19 April 2022

APA Reference: 447482, 451182, 451741
Your Reference: SSD10387

RE: Proposed development of Darroobalgie Solar Farm
State Significant Development Application Number SSD10387

Figure 1 Core development area site location

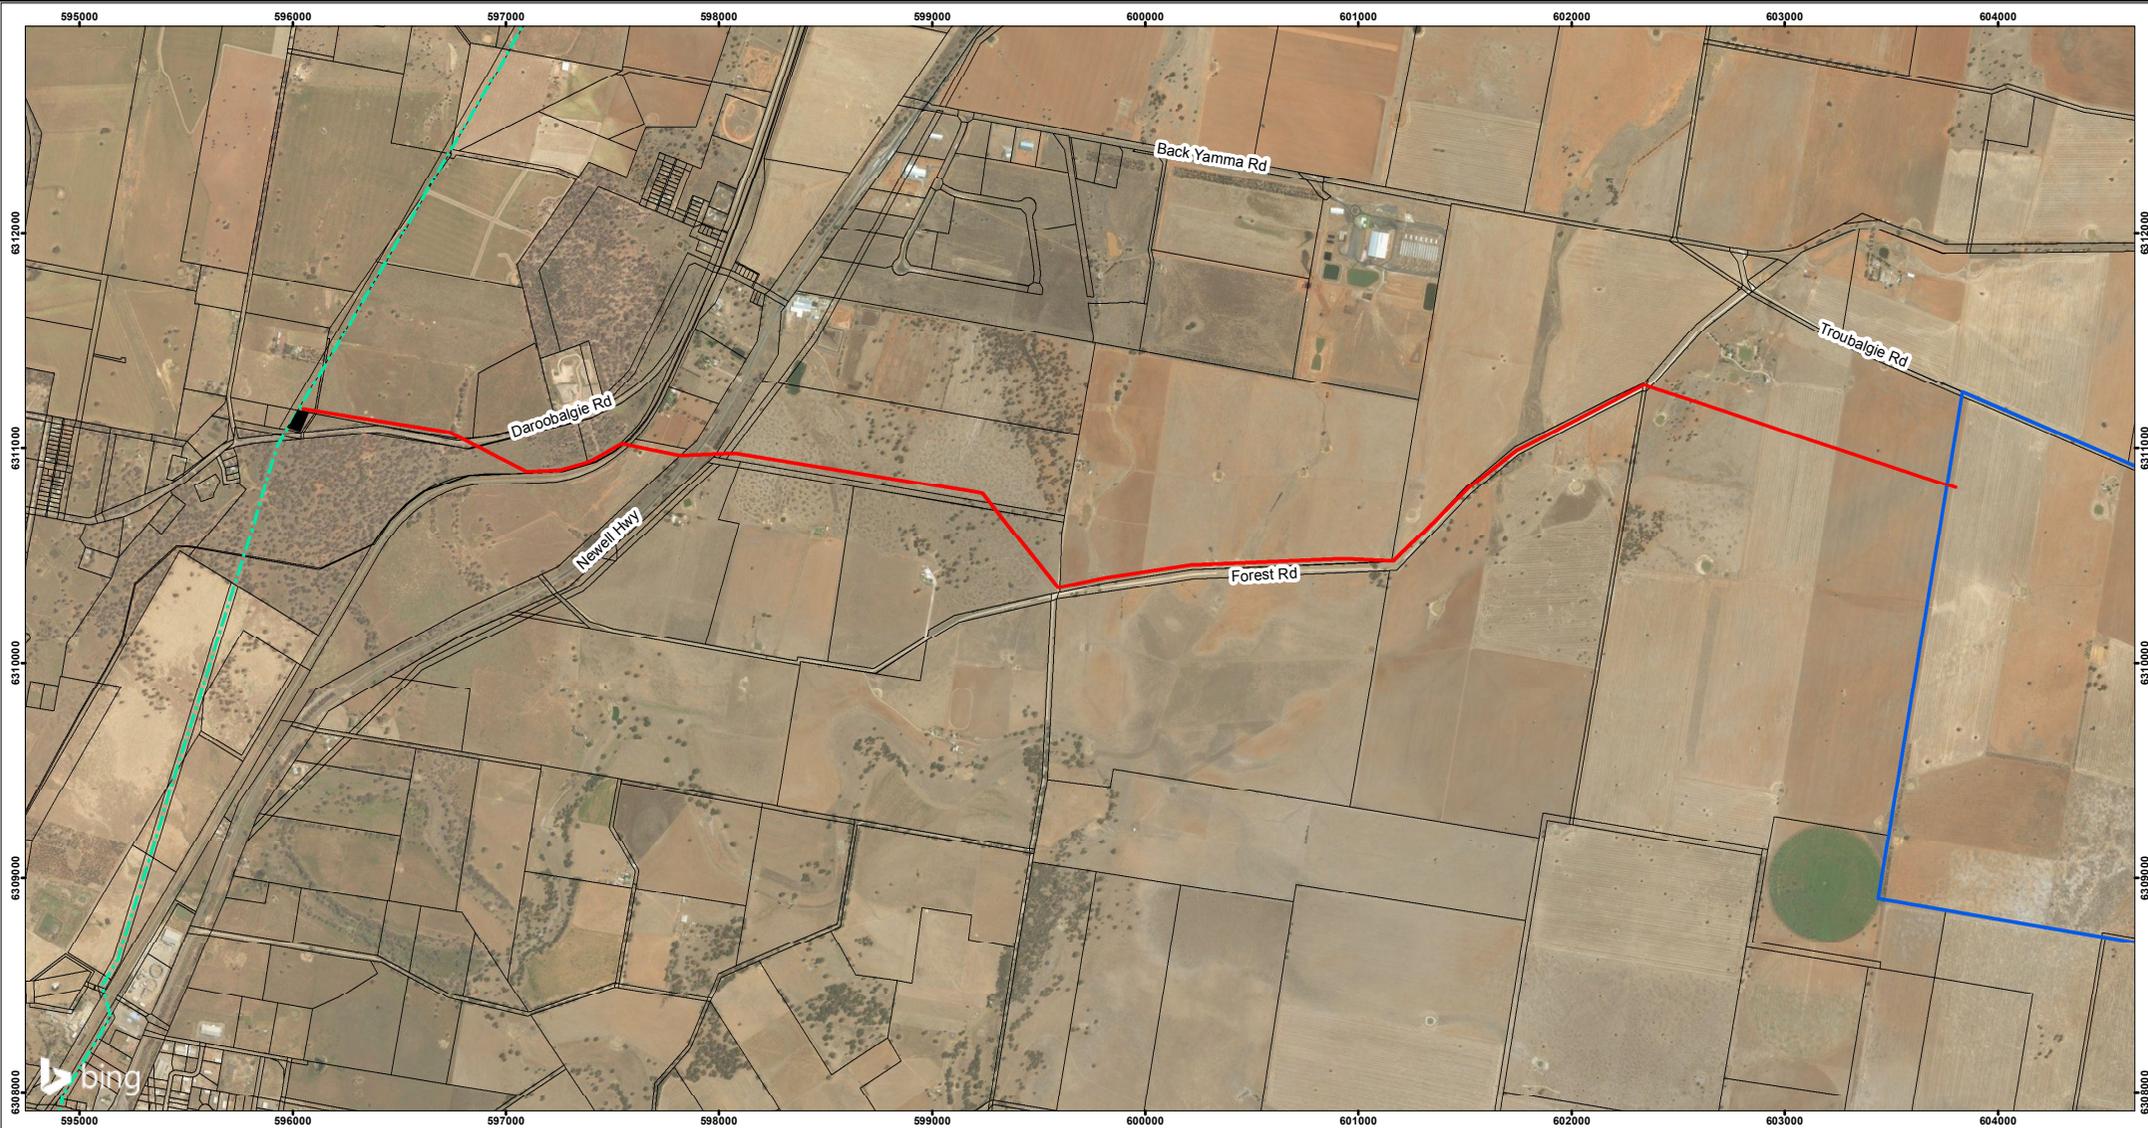
The EIS identifies an electricity transmission line connecting to the solar farm as a component of the development proposal. The electricity transmission line crosses the pipeline easement approximately at Lot 1664DP750158 and runs south west adjacent the pipeline easement for 500m.

The proposal plan indicates the development footprint is located approximately 11kms to the east of APA's pipeline and easement and identifies an electricity transmission line crossing and then running adjacent to the pipeline easement.

A switchyard is located to the south-west of the development site and west of APA's pipeline. Regardless of the final area for the switchyard, the need for crossings of the pipeline is anticipated. These are expected to include:

Details of all proposed crossings, and works within the easement, must be submitted to APA for consideration. No crossings may occur without the prior authorisation of APA, and must be completed in accordance with any conditions imposed by APA. This includes the existing location of the proposed pipeline crossing.
